EROSION AND STORMWATER QUALITY CONTROL PERMIT (ESQCP) EL PASO COUNTY APPLICATION AND PERMIT

Add PCD File Number PPR-19-045

Project Information	
Project Name	TAMLIN ROAD RV STORAGE
Legal Description	TRACT IN SW4NW4 SEC 21-13-65 AS FOLS, COM AT W4 COR OF SEC 21, TH N 89<35'44" E ON E-W C/L 153.32 FT FOR POB, CONT ON LAST COURSE 1167.25 FT, N 0<21'38" W 1275.57 FT, S 40<04'005" W ON SELY R/W LN OF TAMLIN RD 844.91 FT, TH S 44< N ON SD LN 885.0 FT TO POB
Address (or nearest major cross streets)	NORTHEAST OF THE INTERSECTION OF MARKSHEFFEL ROAD AND TAMLIN ROAD.
Acreage (total and disturbed)	Total: 16.5 ACRES Disturbed: 10.9 ACRES
Schedule	Start of Construction: MARCH 2020 Completion of Construction: AUGUST 2020 Final Stabilization: NOVEMBER 2020
Project Purpose	TO PROVIDE 290+/- RV PARKING/STORAGE SPACES.
Description of Project	THE PROJECT CONSISTS OF GRAVEL DRIVE AISLES, GRAVEL PARKING SPACES AND A SINGLE FULL SPECTRUM WATER QUALITY AND DETENTION POND.
Tax Schedule Number	206141281

A TRACT OF LAND IN THE SOUTHWEST QUARTER OF THE NORTHWEST QUARTER IN SECTION 21,
TOWNSHIP 13 SOUTH, RANGE 65 WEST OF THE 6TH P.M.
EL PASO COUNTY, COLORADO
SITE PLAN

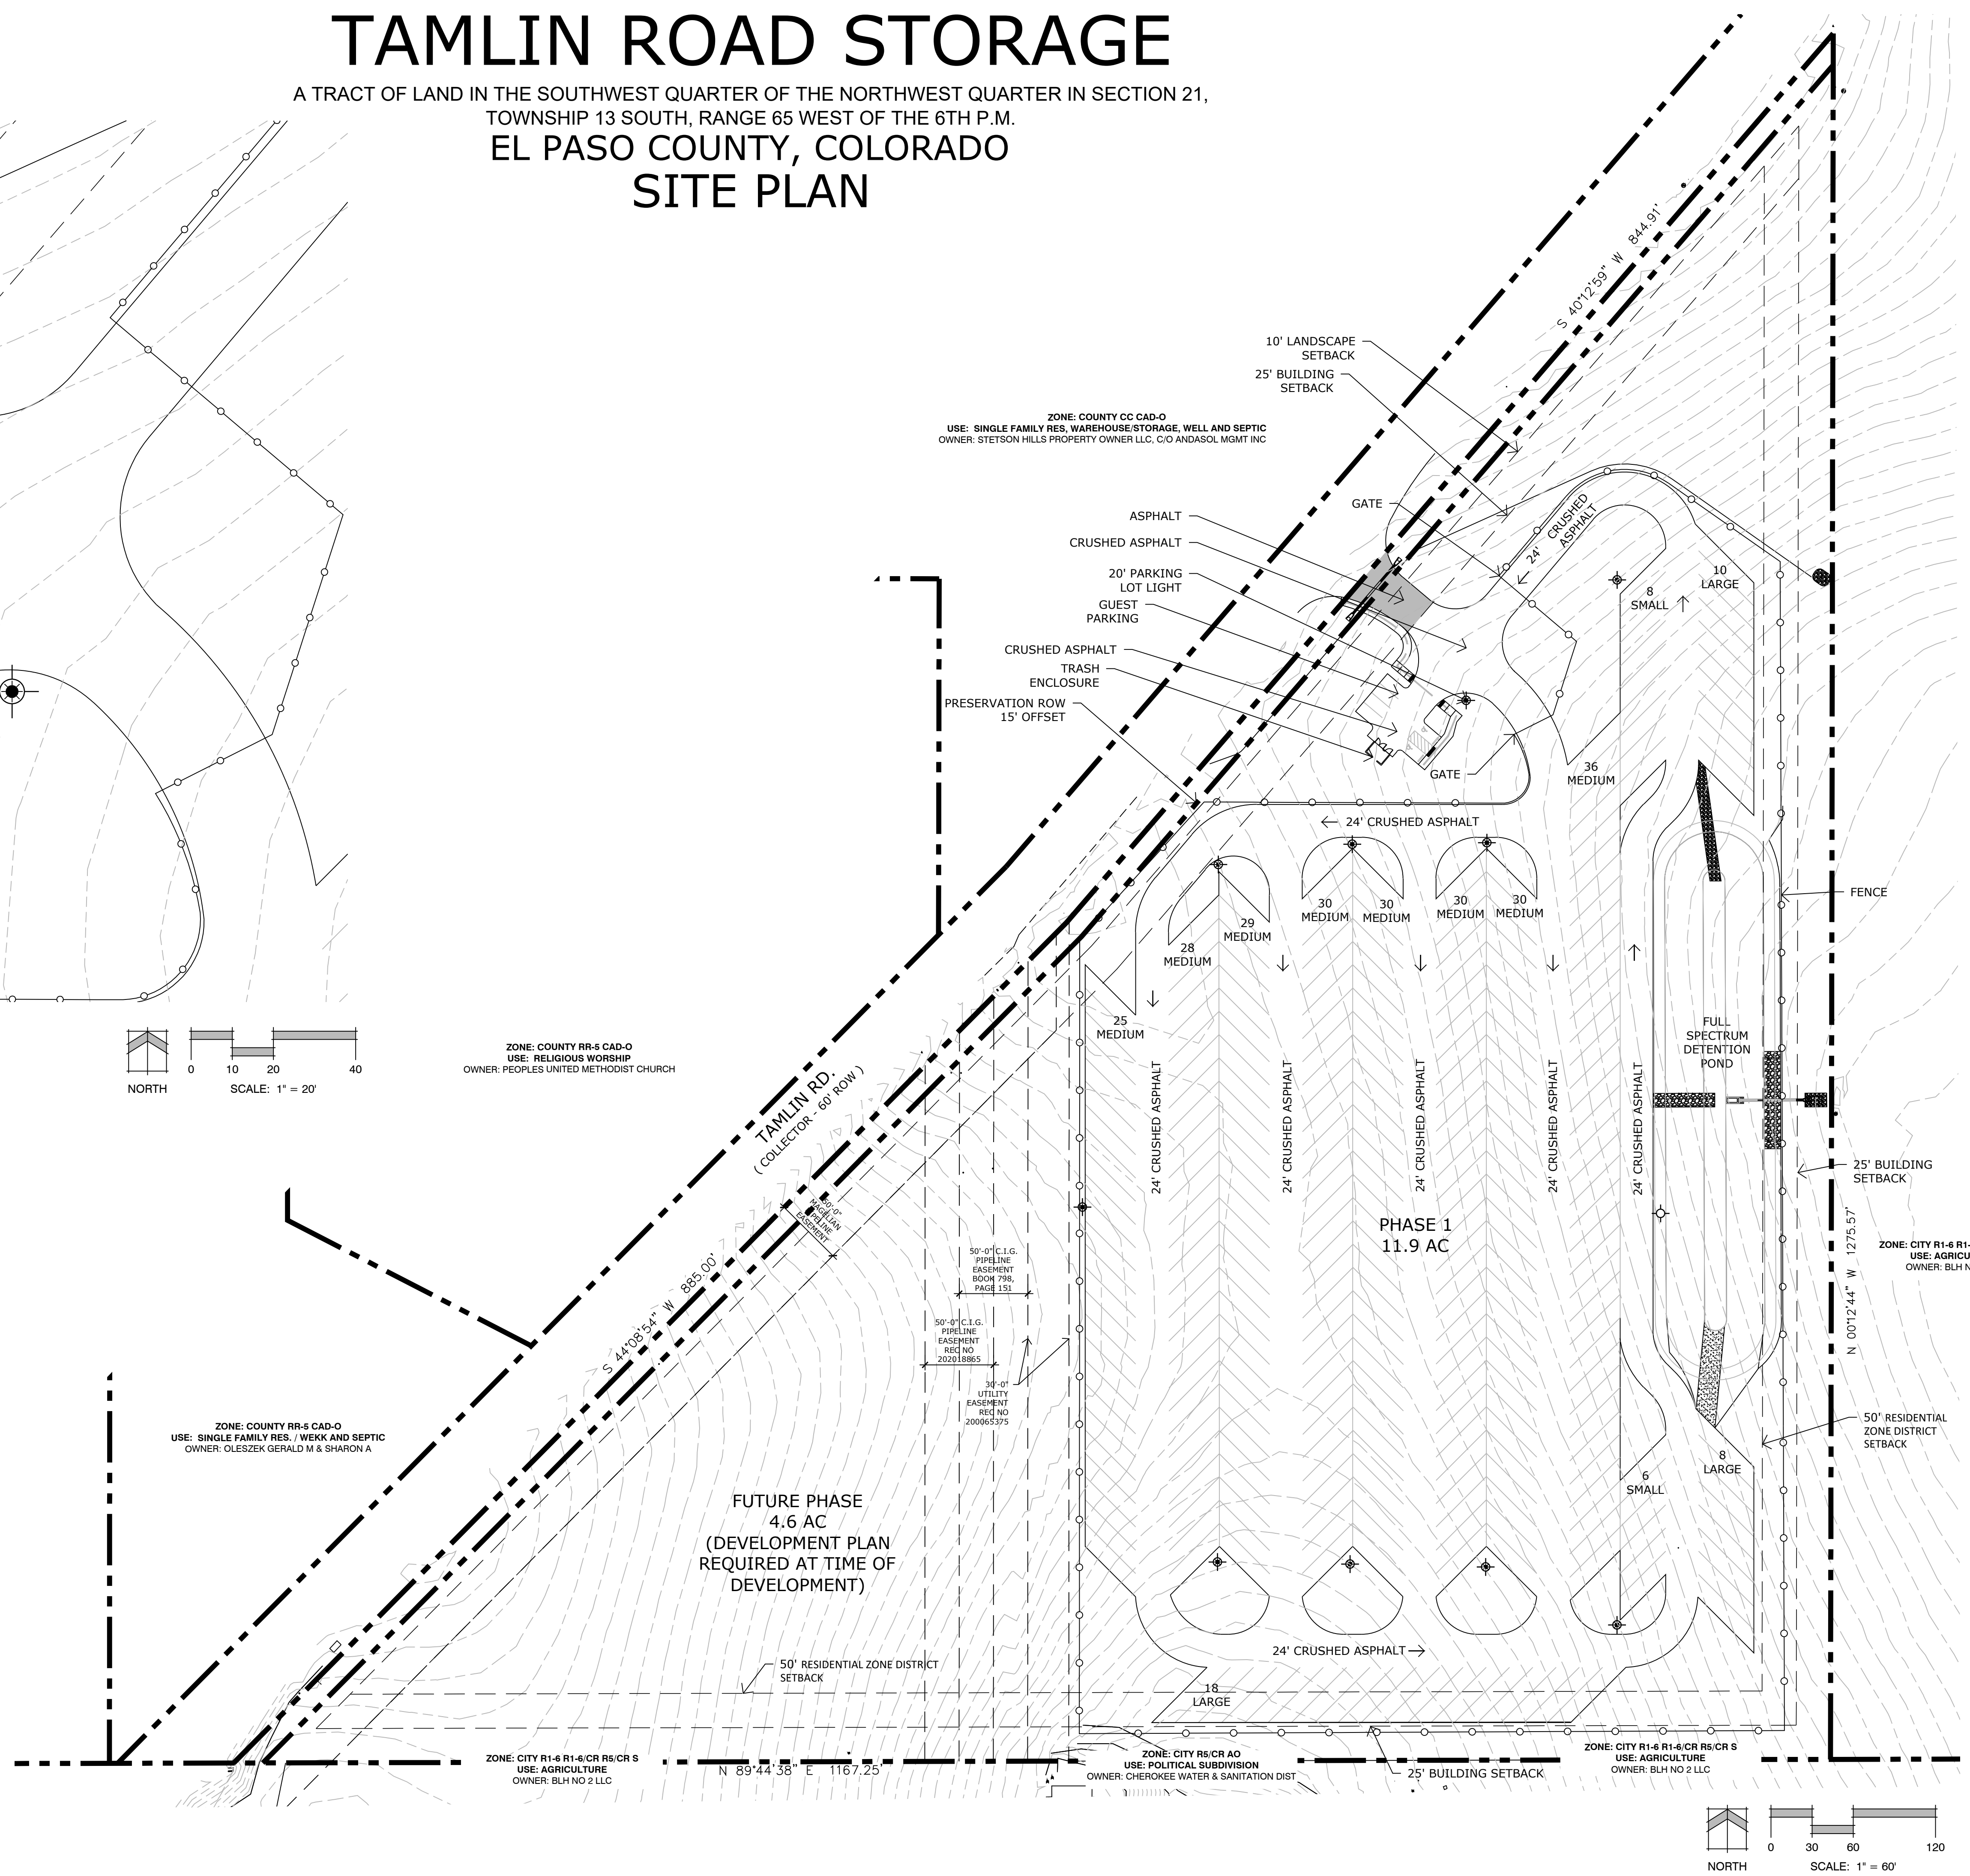
The site plan indicates drive aisles and parking as asphalt. Please revise accordingly.
